Subject: FW: LU/134/21/PL & LU/135/21/L The Farm, East Street, Littlehampton - CONSERVATION OFFICER COMMENTS FIREPLACE

Pls add below email to case files x 2 as above and label as 'Conservation Officer comments – re fireplace/chimney breast proposals'

Drawing No
203104/ 03

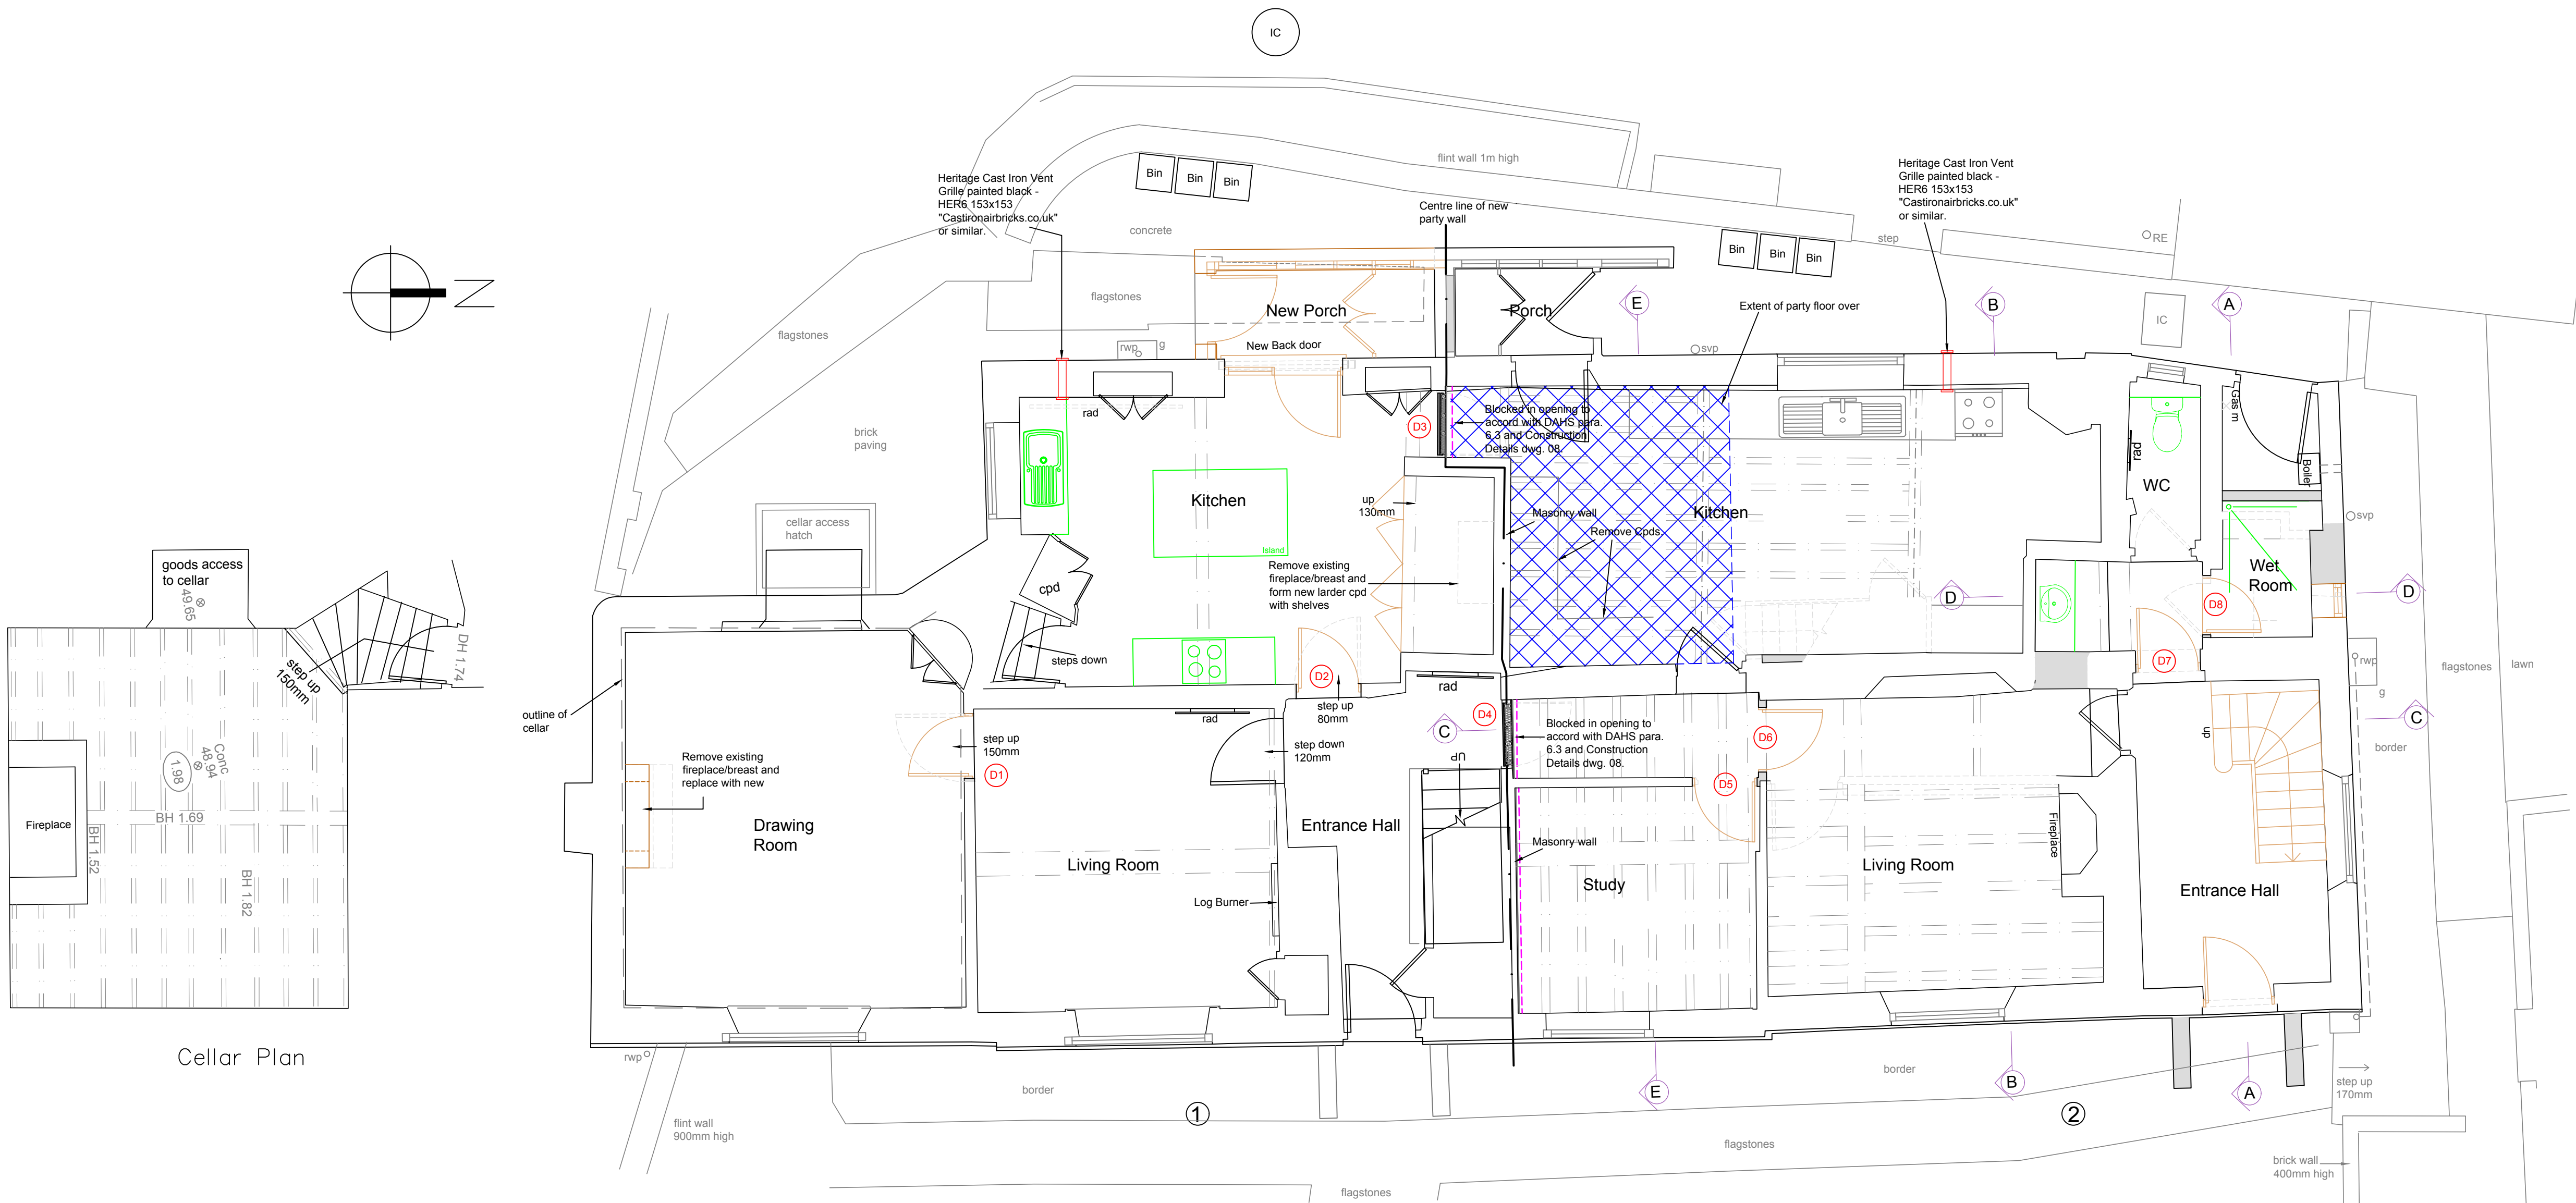
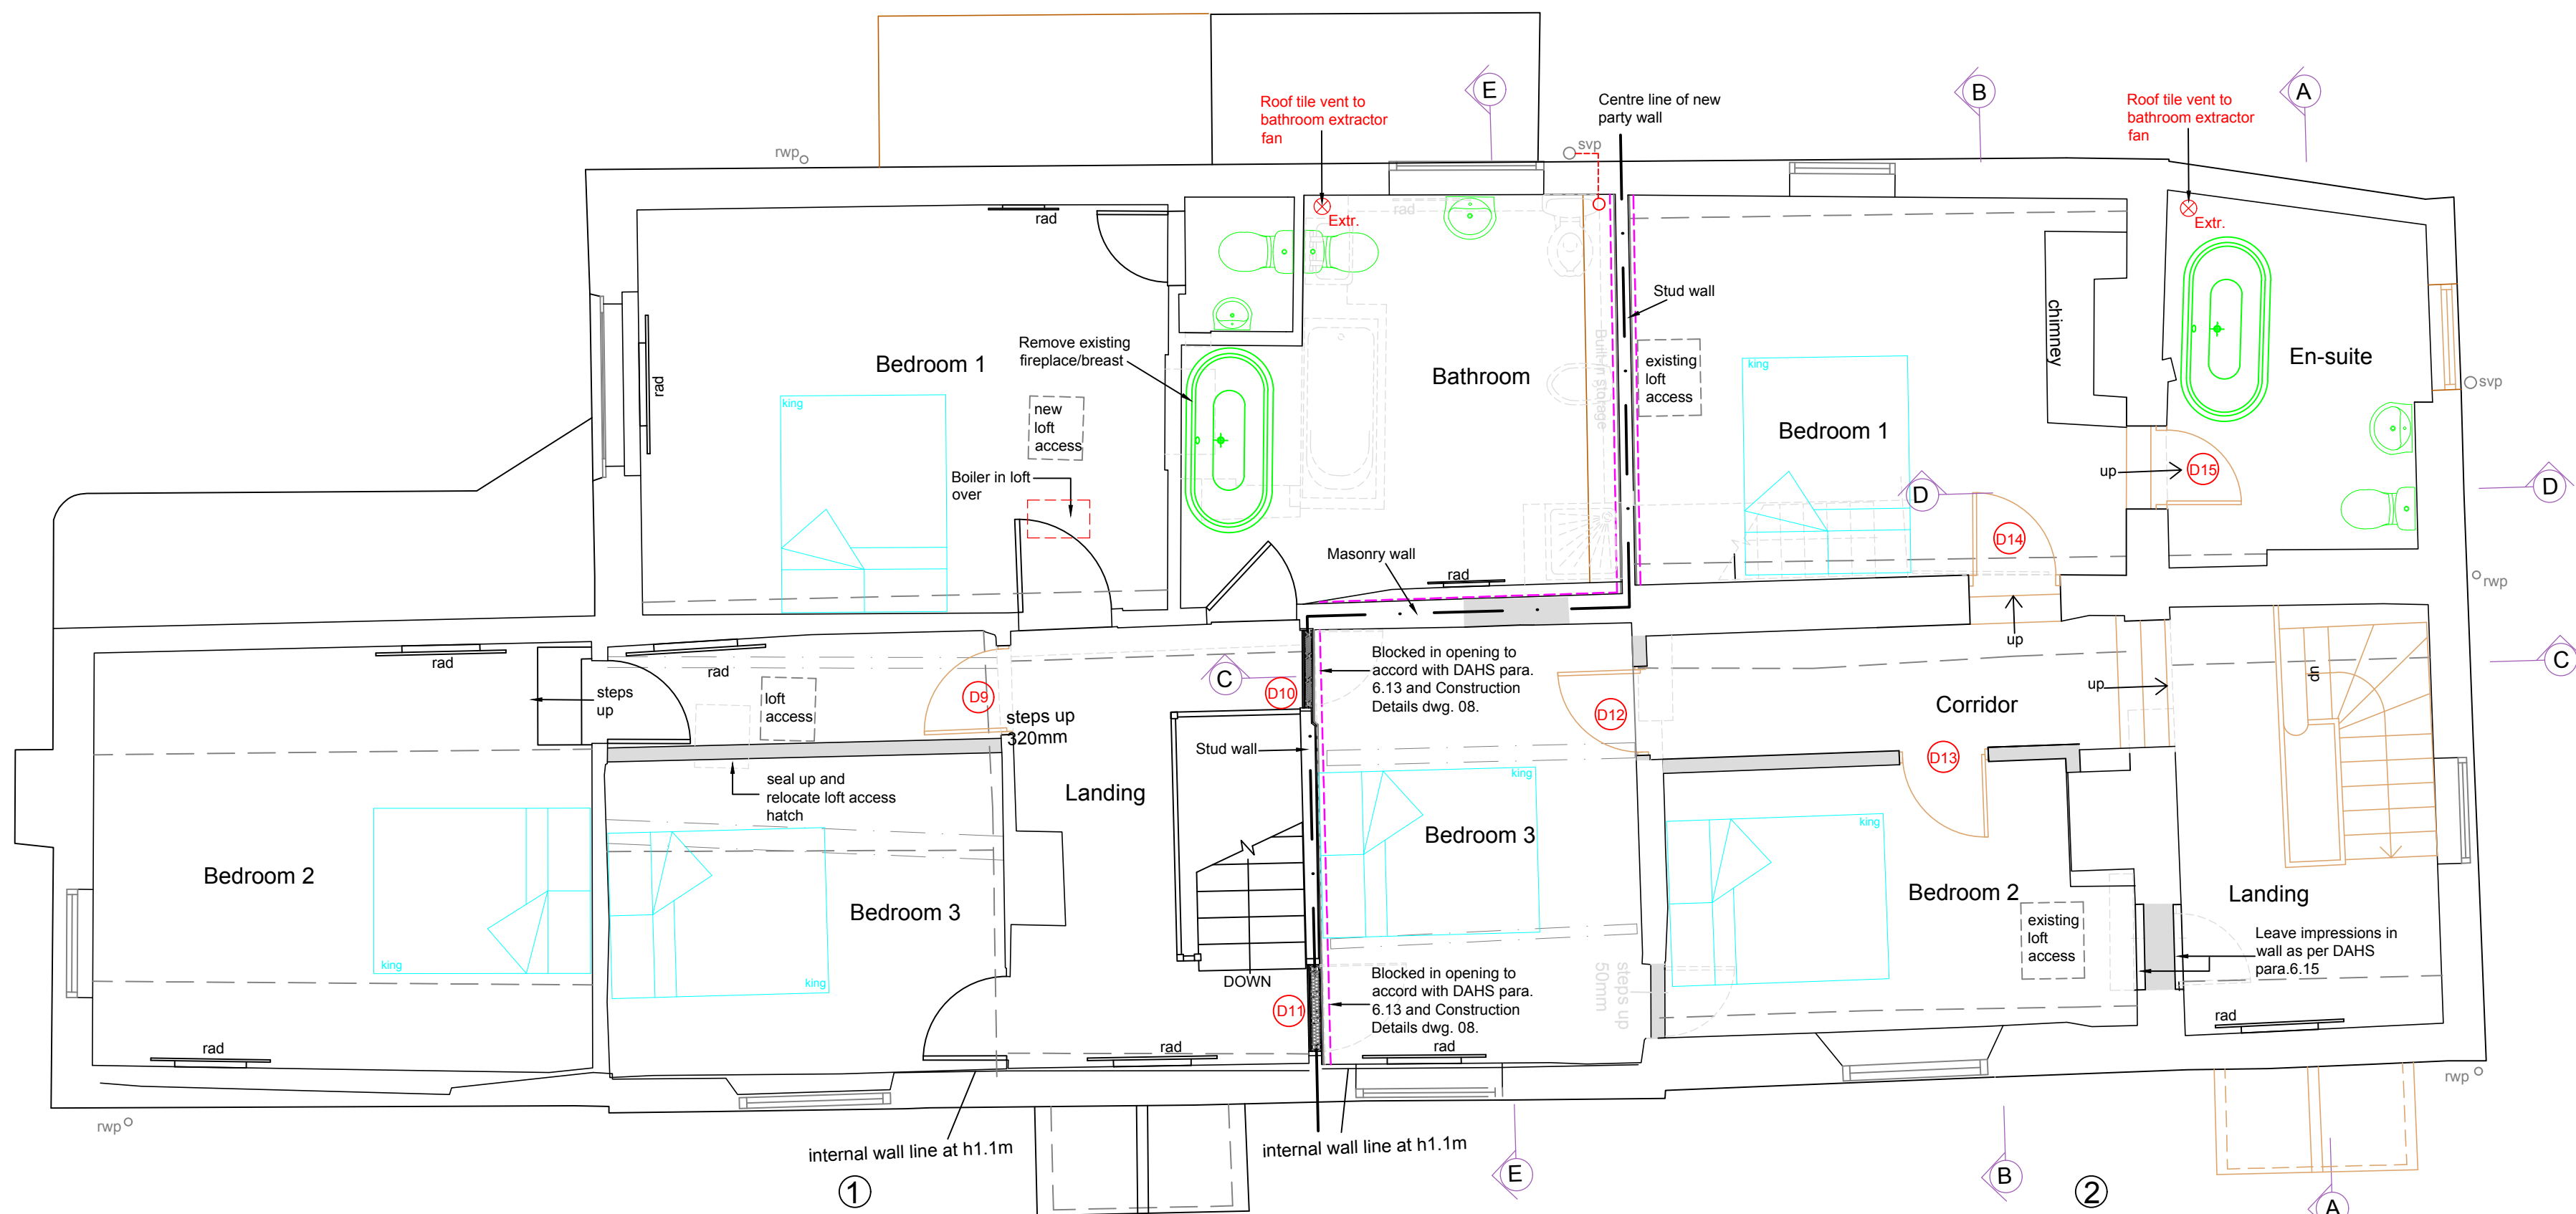
Why is there loss of the fireplace/chimney breast at the first floor level in the existing bathroom. It is not clear why this has to be removed, and ideally it would be retained?

In respect to your concern over the loss of the fireplace / chimney breast in the bathroom, I have discussed this with our clients, and confirm they are happy that it is retained. The existing fireplace is a later addition(please see attached image). The proposal is now to simply remove this more recently added fireplace at ground floor to bring it back to the original form, as shown in a picture in the attached document, and the larder to be built around it and retain the structure above.
